Dear Mr Pearce

Thank you for your email and telephone conversation regarding the above building. I note that you have provided some basic information regarding your proposals, and these have been used to provide my comments.

PROPOSED FIRST FLOOR PLAN

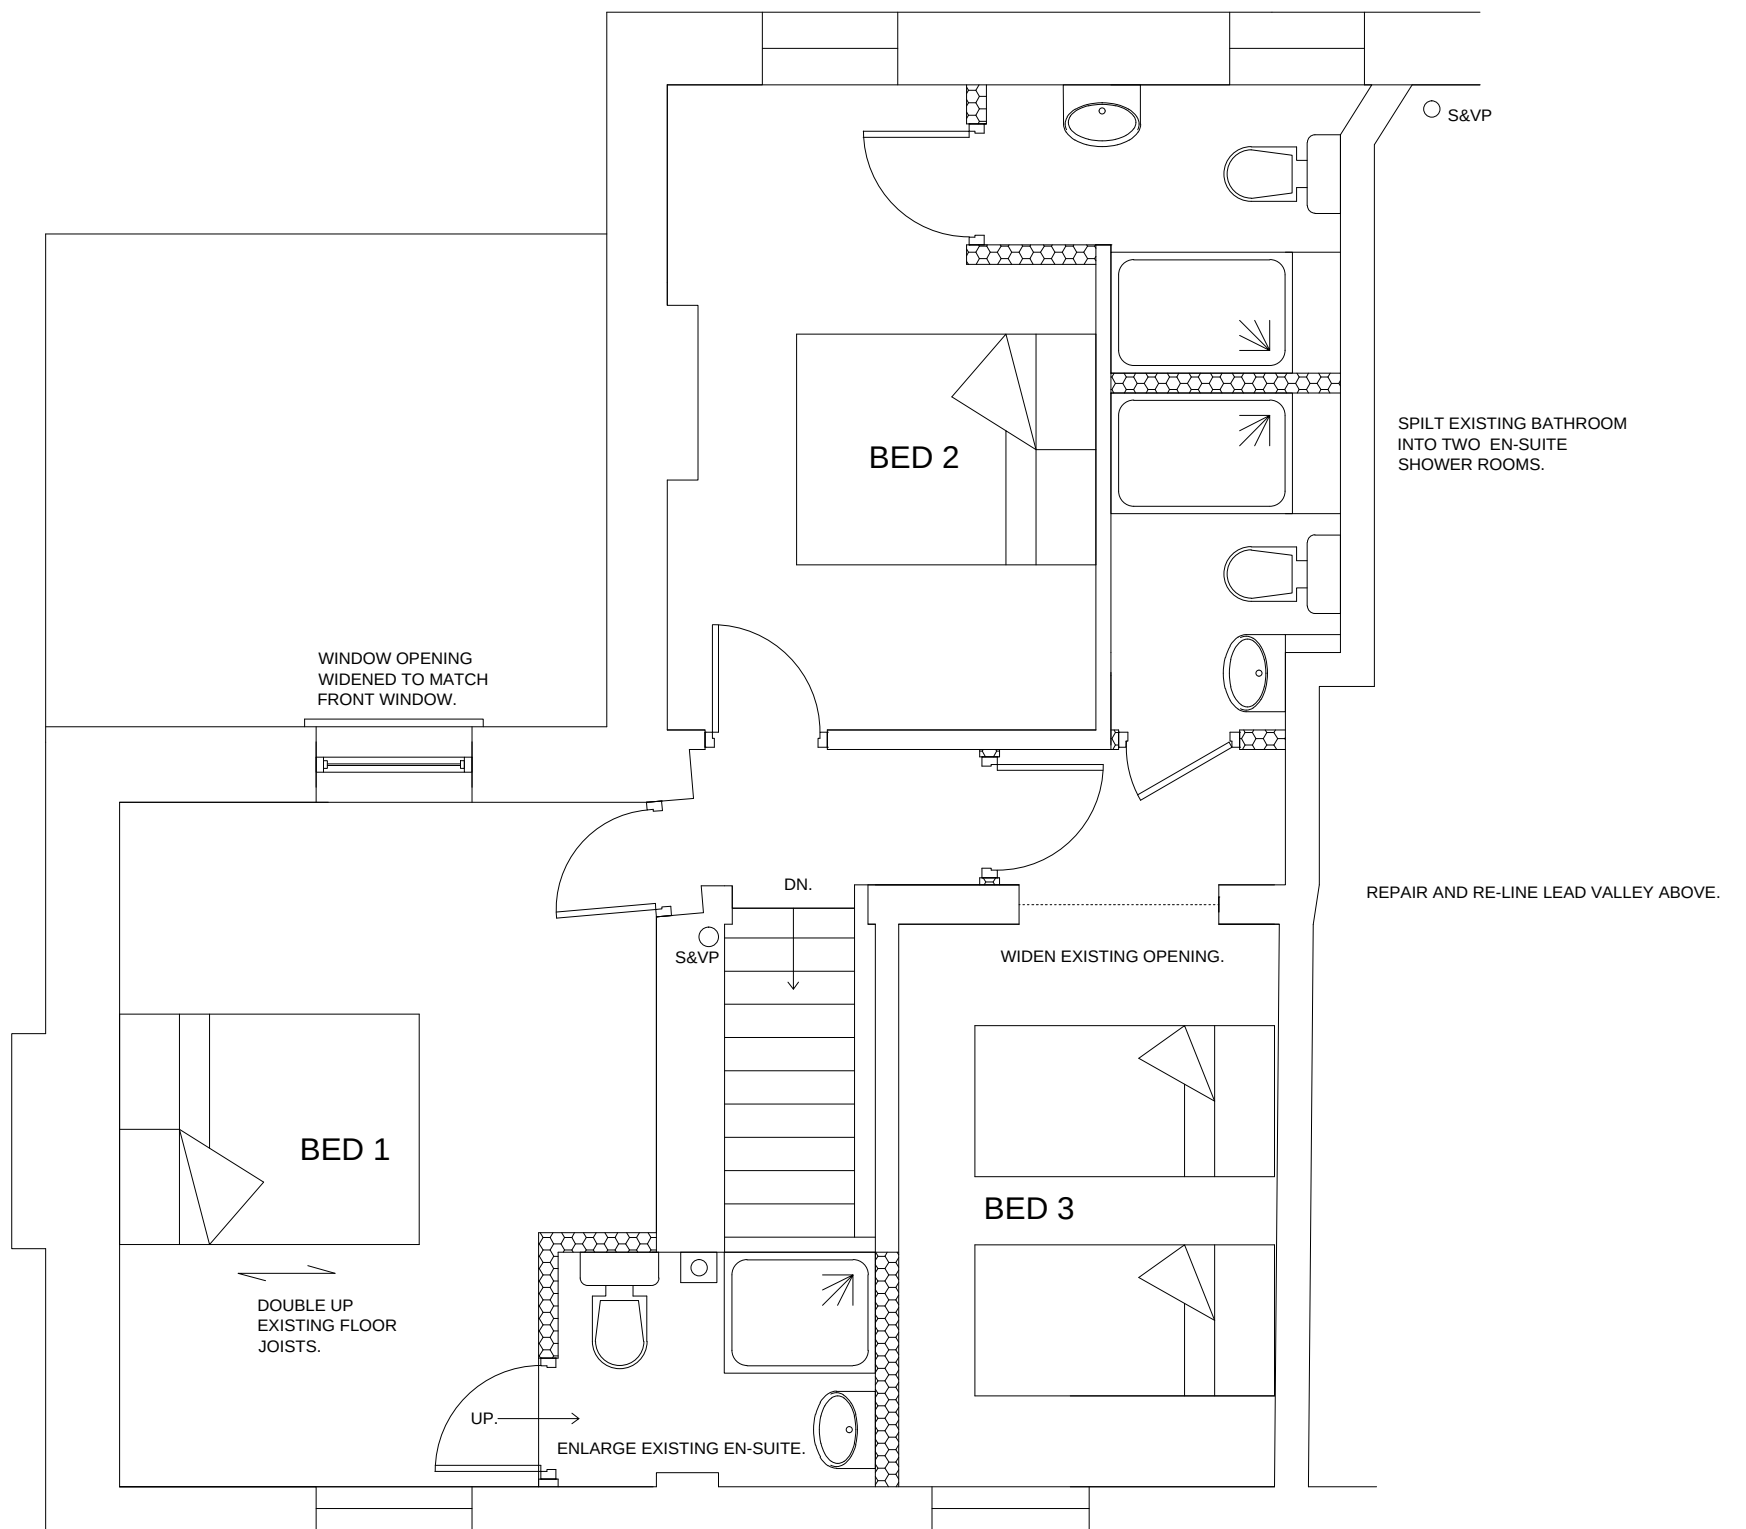
- The proposed works to the first floor appear to be acceptable; the sub-division of the bathroom to create two rooms will not harm the character of the building. This is subject to joinery etc matching the existing and issues related to drainage being dealt with.

PROPOSED GROUND FLOOR PLAN

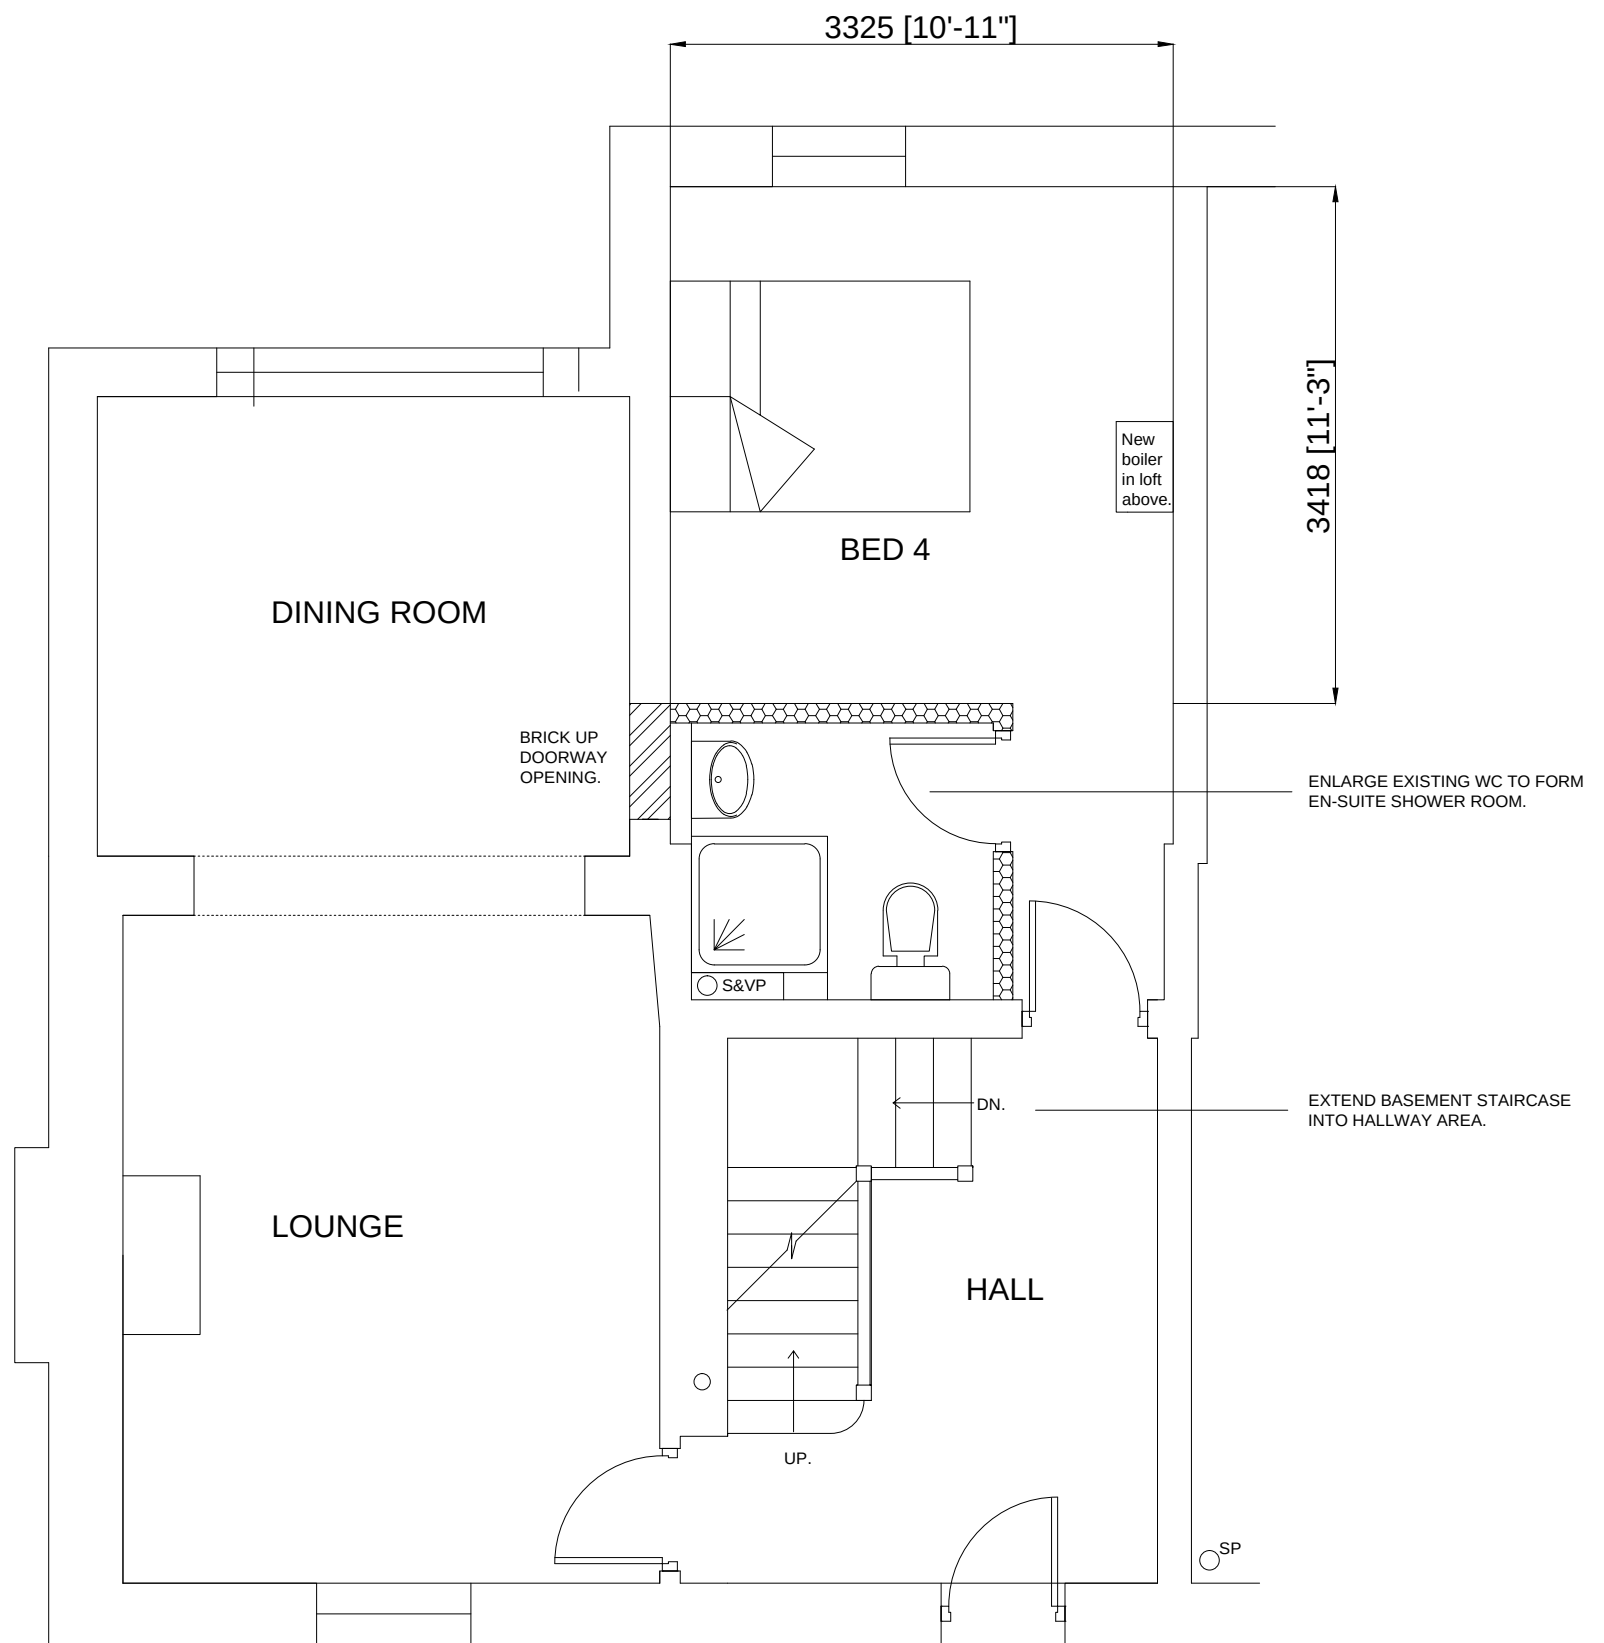
- The proposed alteration to the existing en-suite to the front of the building are small in scale and acceptable.
- Converting the existing kitchen into an additional bedroom is acceptable, subject to details of the introduction of the en-suite – where would it be located, and how would issues related to drainage be considered etc?

- It is not clear how you would alter the stairs? Would they stay in the same location, but be upgraded? As they lead to a basement level, they should be of a simple style to reflect the status of the lower floor.

- It is not clear from the information provided what is meant by 'Form light well' please can this be clarified?
- It would also appear that you are proposing a new porch and/or bay window? Whilst there is a bay window next door, this property appears to retain its original façade, and this proposal would result in the loss of historic fabric and alter the older façade. As a consequence, it is considered that this would harm the significance of this building and cannot be supported.

PROPOSED LOWER GROUND FLOOR PLAN

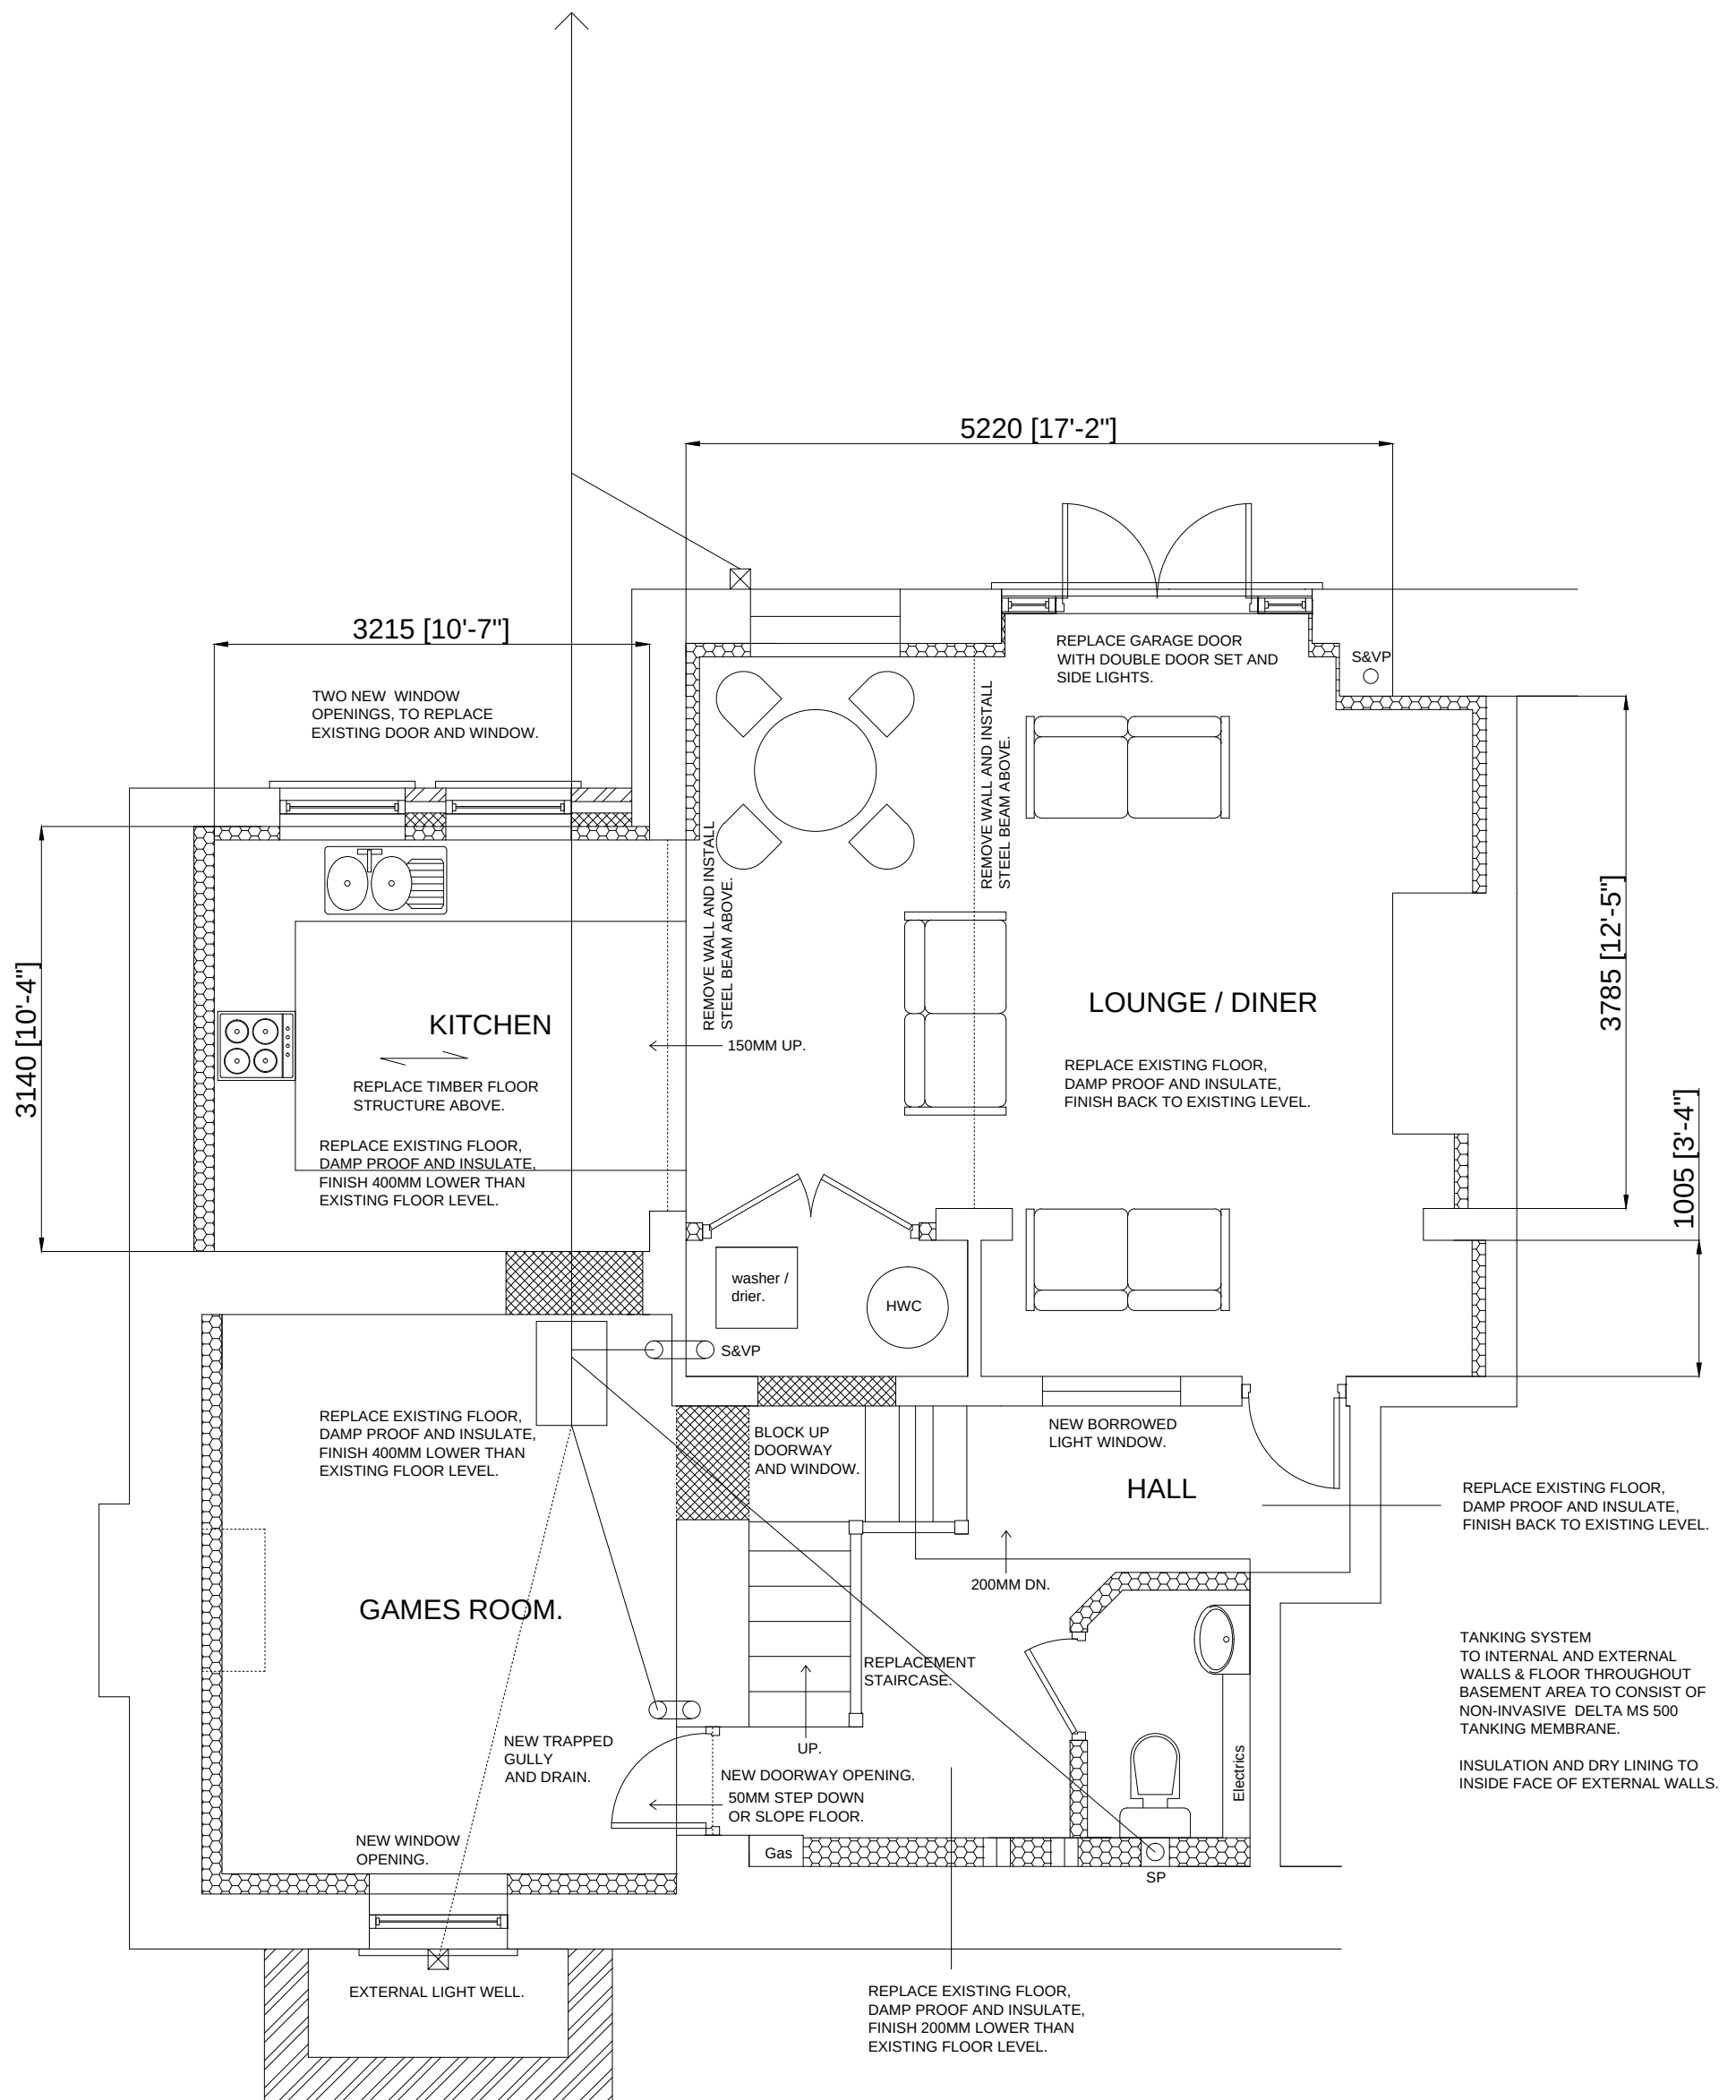
- The proposal to the basement level will have the greatest impact. Works should not remove all of the walls within the area. There should be some way of understanding the existing floor plan. Nibs of existing walls should be kept. The lowering of the section of flooring appears to be acceptable, subject to confirmation that they can be undertaken from a structural perspective (I am not a structural engineer).
